Maritime and Coastguard Agency
UK Technical Services Navigation
105 Commercial Road
Southampton
SO15 1EG

20 June 2023

Application by Equinor for an Order Granting Development Consent for the Sheringham and Dudgeon Extension Projects.

Examination Timetable – Deadline 6

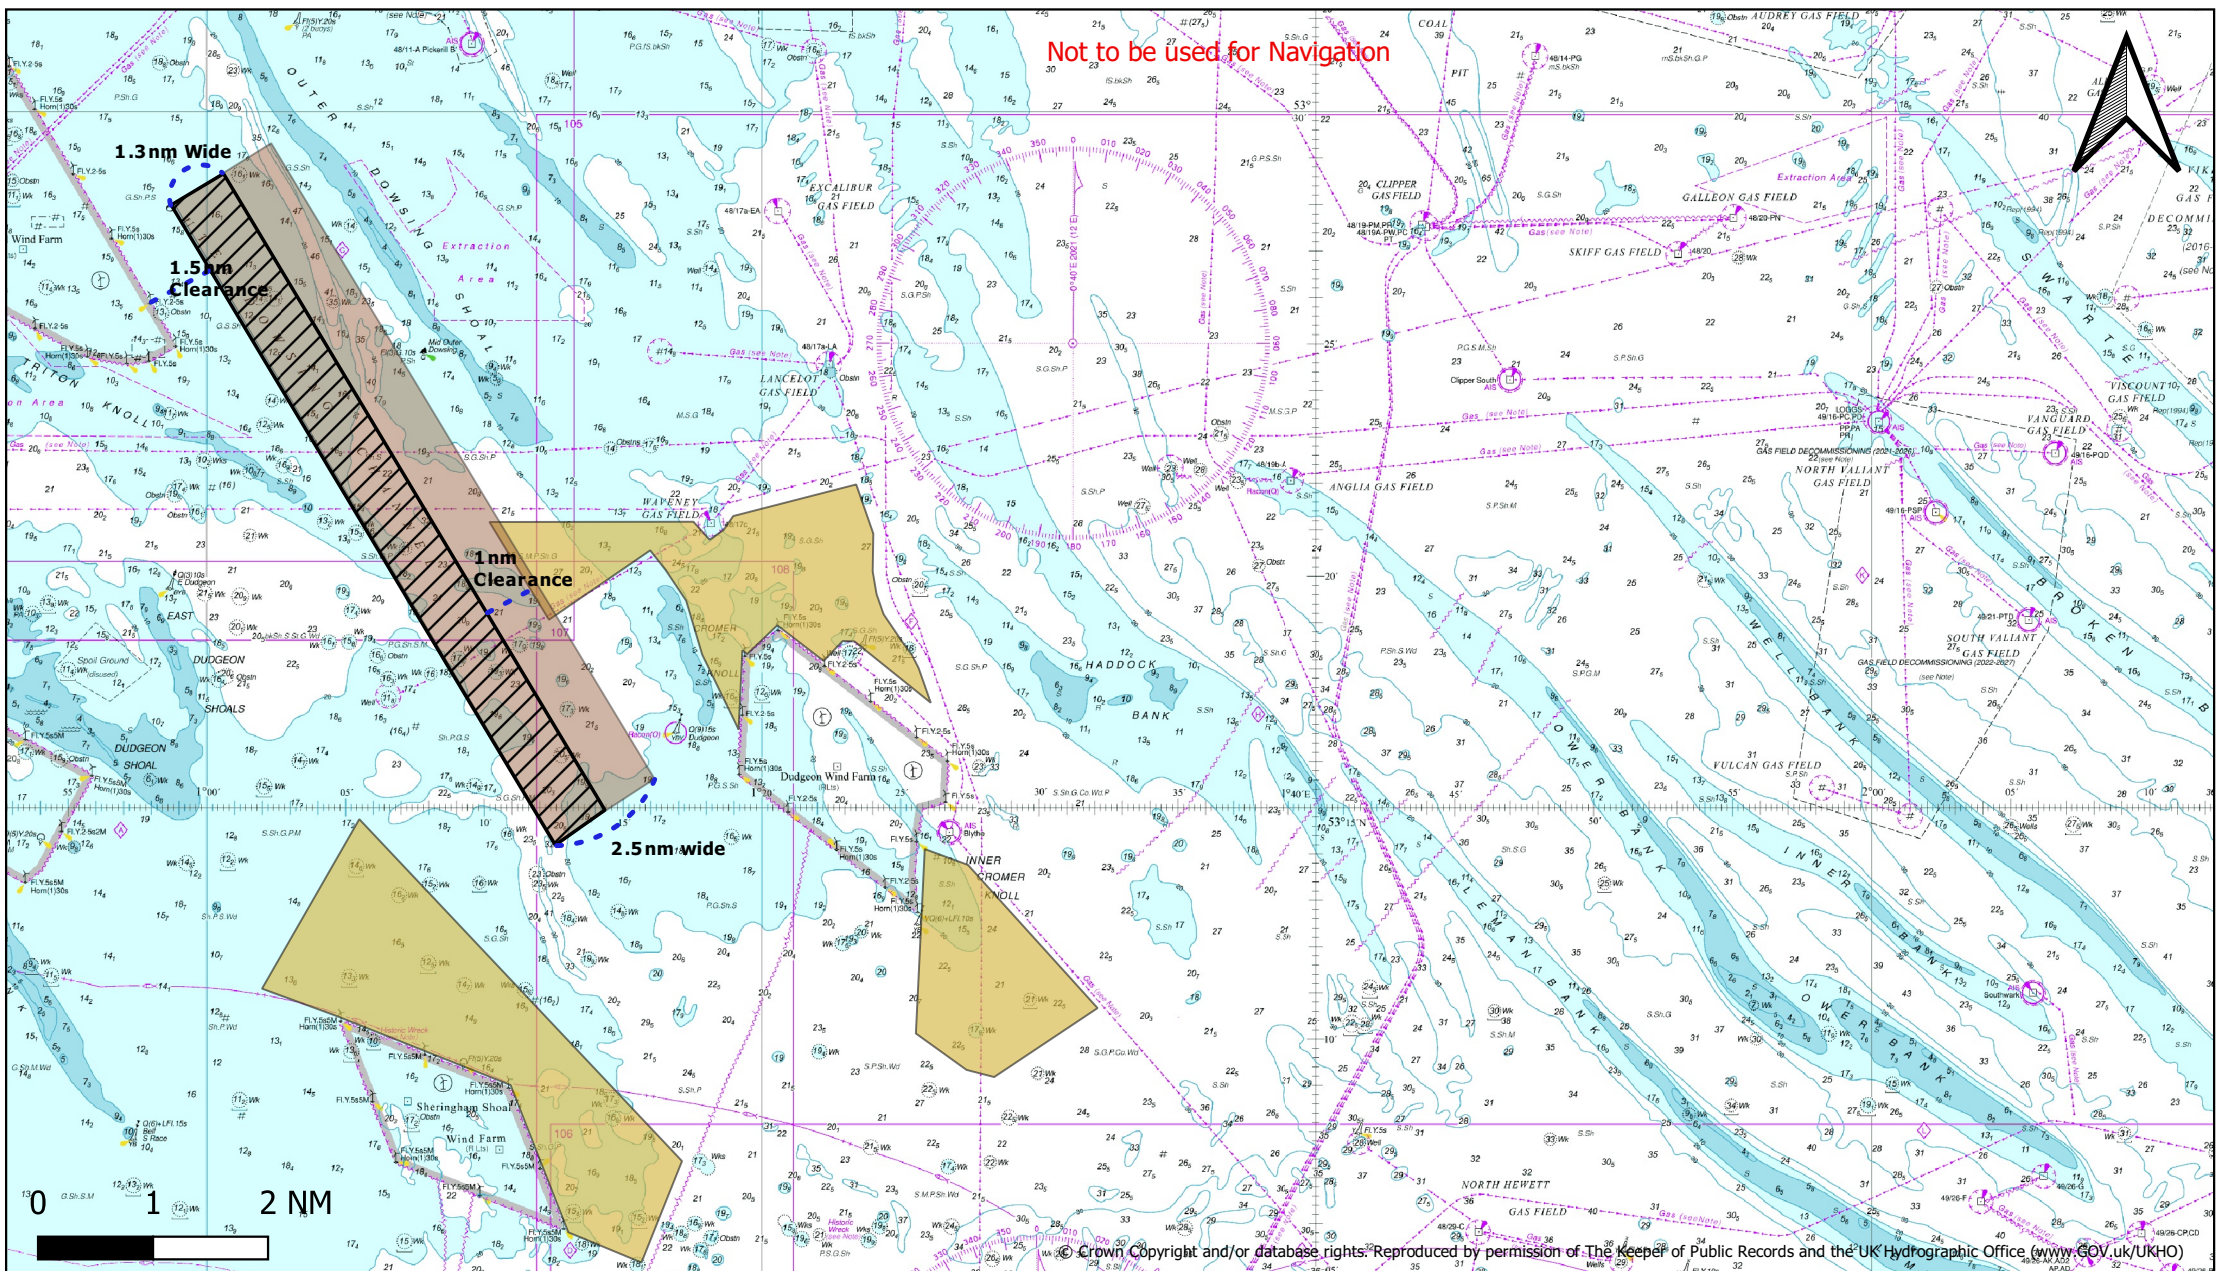
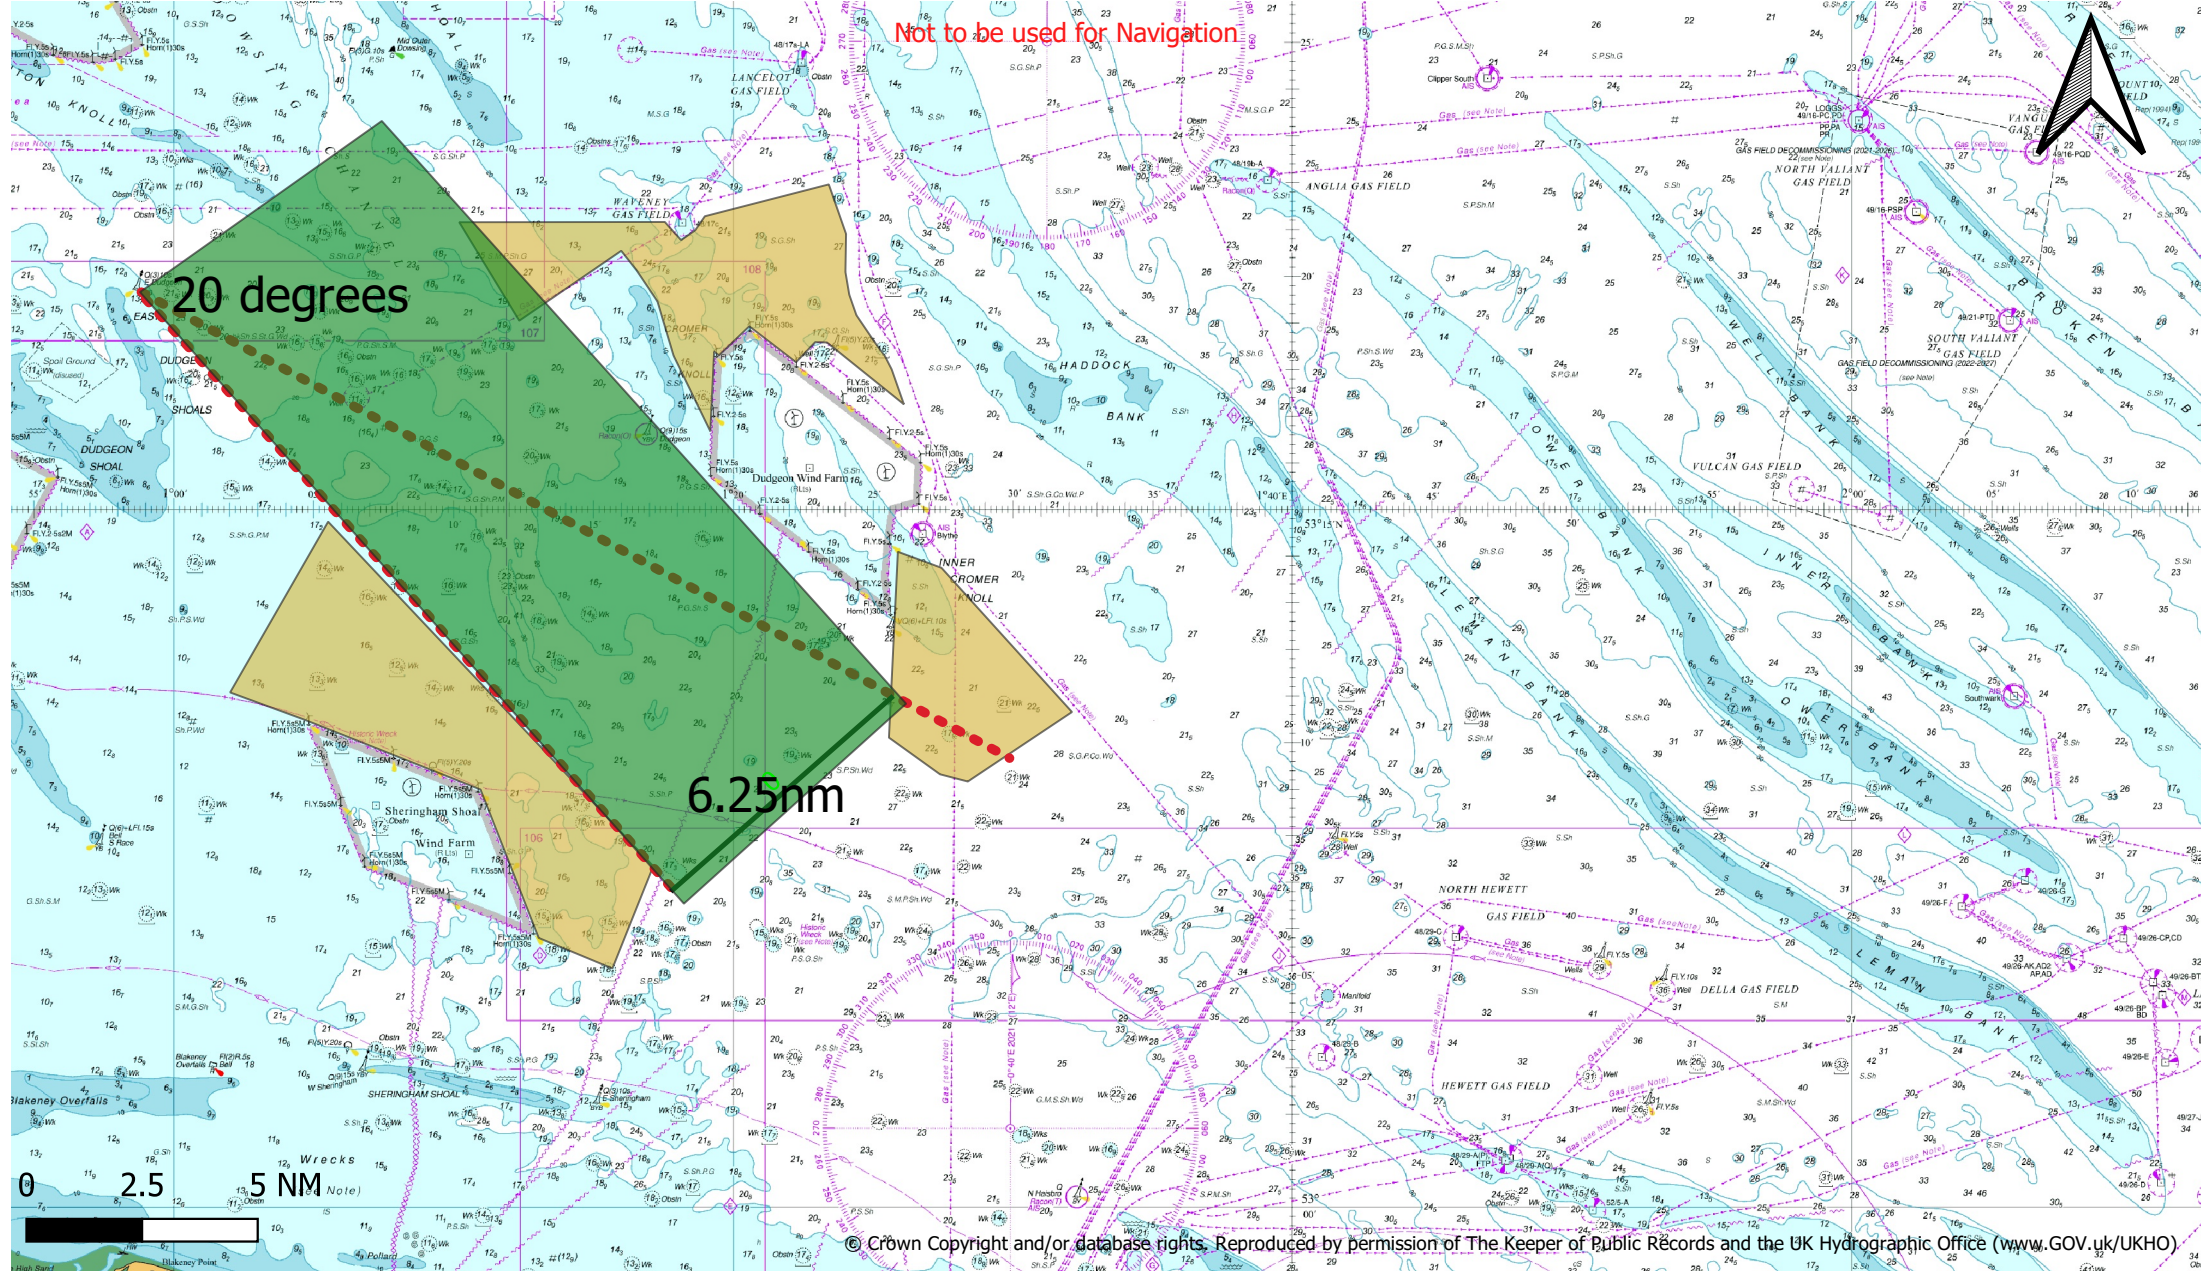
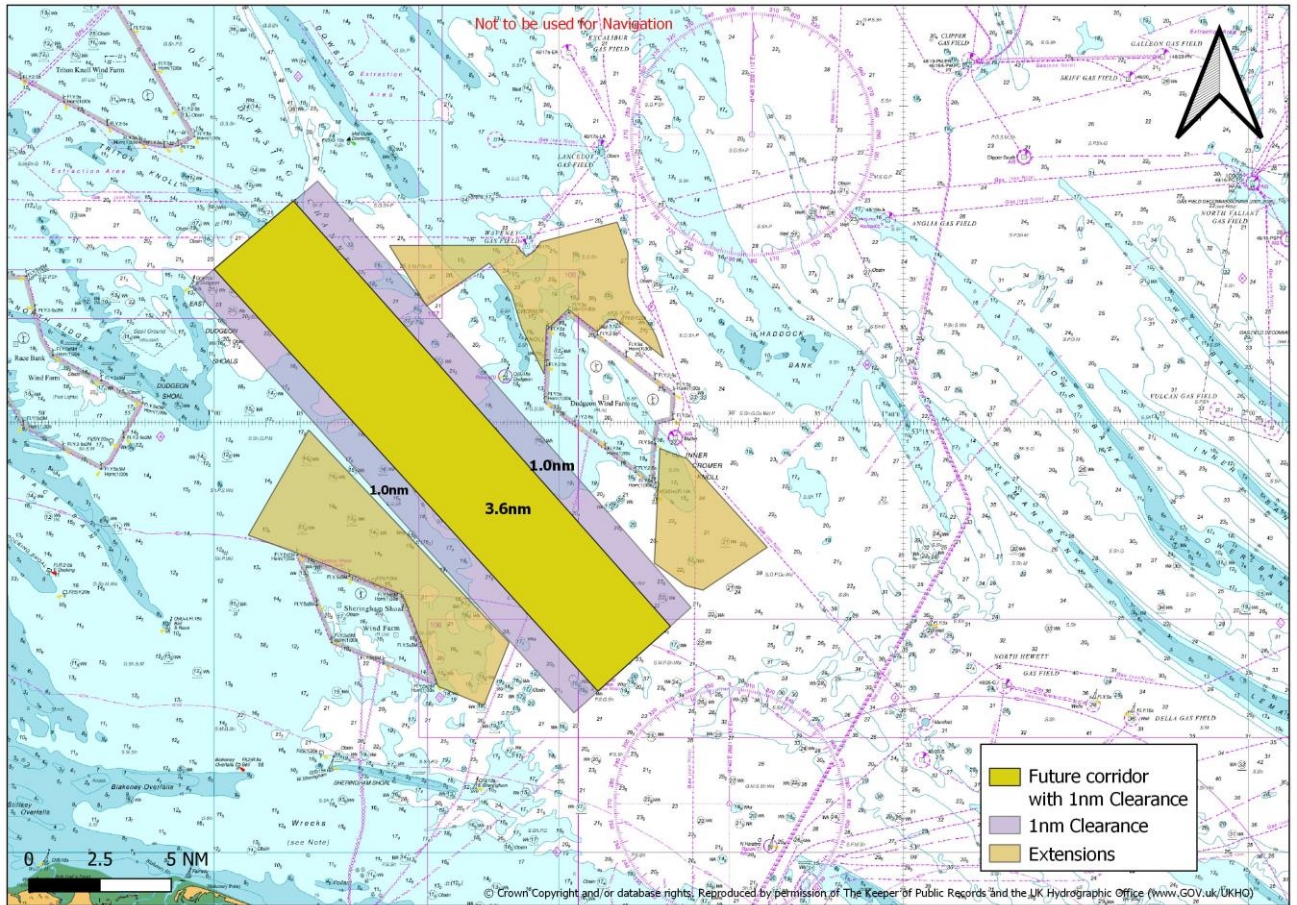
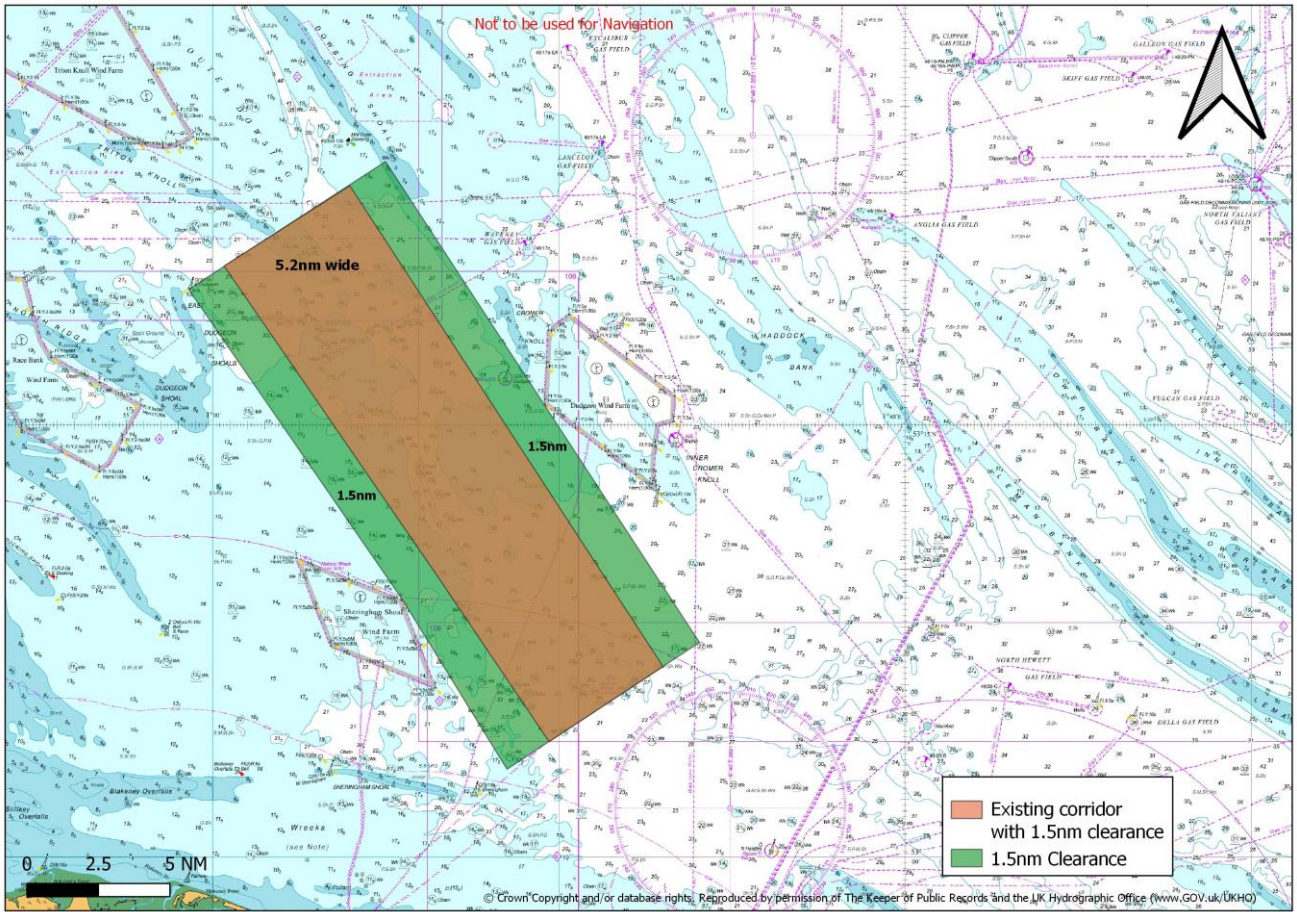
ID	Applicant's Comment	MCA Responses	Applicant's Comment	Additional MCA Comments
6 Passing Distance Para 51				
8	<p>Given the local features present (see Figure 6.1), and local evidence of vessels passing closer than 1nm to existing wind turbine generators in the area (see Figure 6.2), it is considered likely that the 1.5nm value referenced by the MCA is not resultant of a deliberate choice by vessels to avoid wind turbine generators by a set distance. It is instead reflective of prudent mariners accounting for other features in the surrounding sea area.</p>	<p>It is agreed that prudent mariners transit 1.5nm from Triton Knoll OWF (as shown in the NRA) due to other navigational features in the area and this will include the avoidance of shallow water. If the DEP North boundary is not reduced mariners will not transit further west to provide more safe sea room due to the Triton Knoll shallow water and waypoint reference in Figure 6.1. Mariners will provide a safety buffer from the DEP North boundary and therefore they will be constricted into a narrower channel.</p>	<p>NRA modelling does not assume that traffic would move further west. The assumed traffic distributions used in the collision risk modelling are narrower than that proposed as worst case in the MCA submission to ISH6 [page 1 of AS-044]. The NRA does consider a 1nm separation from the route median line and therefore a 0.5nm separation between the nearest shipping 90% traffic level and the project boundary (Modelling Visualisation figure within A.2 of Supporting Documents for the Applicant's Responses to the Examining Authority's Third Written Questions [document reference 19.2.1]). This assumption is standard practice in collision risk modelling and in this case is considered as modelling a worst-case compression of traffic while still maintaining proximity of traffic to the structures to ensure collision risk is captured. This assumption is also supported by practice observed at the existing Dudgeon Offshore Wind Farm and other sites from around the UK (Vessel Passing Distances from UK Wind Farms Note within A.2 of Supporting Documents for the Applicant's Responses to the Examining Authority's Third Written Questions [document reference 19.2.1]).</p>	<p>It is agreed that traffic will not move further west, yet the Applicant uses a line extending the 10m contour which increases the navigable width by 1.5nm.</p> <p>MCA's assessment, submitted at Deadline 5, was that traffic would be squeezed into a corridor 1.3nm wide. The western extent of future traffic in the Applicant's Navigation Technical Note [REP3-031] uses a line extending from the 10m contour. The MCA's assessment uses the 15.3m wreck which lies further east of the 10m contour line. As such the traffic distribution of the Applicant's assessment is wider than the MCA's submission at Deadline 5.</p> <p>The 1nm separation should be measured from the edge of the 90% percentile, as per the MCA's Wind Farm Shipping Route Template in MGN654 Annex 2, not the median line.</p> <p>The assumed traffic distribution used in the collision risk modelling is not narrower than in MCA's assessment. The image in the Applicant's A.2 of Supporting Documents for the Applicant's Responses to the Examining Authority's Third Written Questions shows their assessment of the future 90% traffic level will be in a corridor 1nm wide and 0.5nm from the boundary. It omits the 1.5nm safe sea room to the west. So their actual assessment of the width of safe sea</p>

ID	Applicant's Comment	MCA Responses	Applicant's Comment	Additional MCA Comments
				room is 2.5nm, whereas MCA assessed the width of safe sea room to be 1.3nm, as per the image in our Deadline 5 submission.
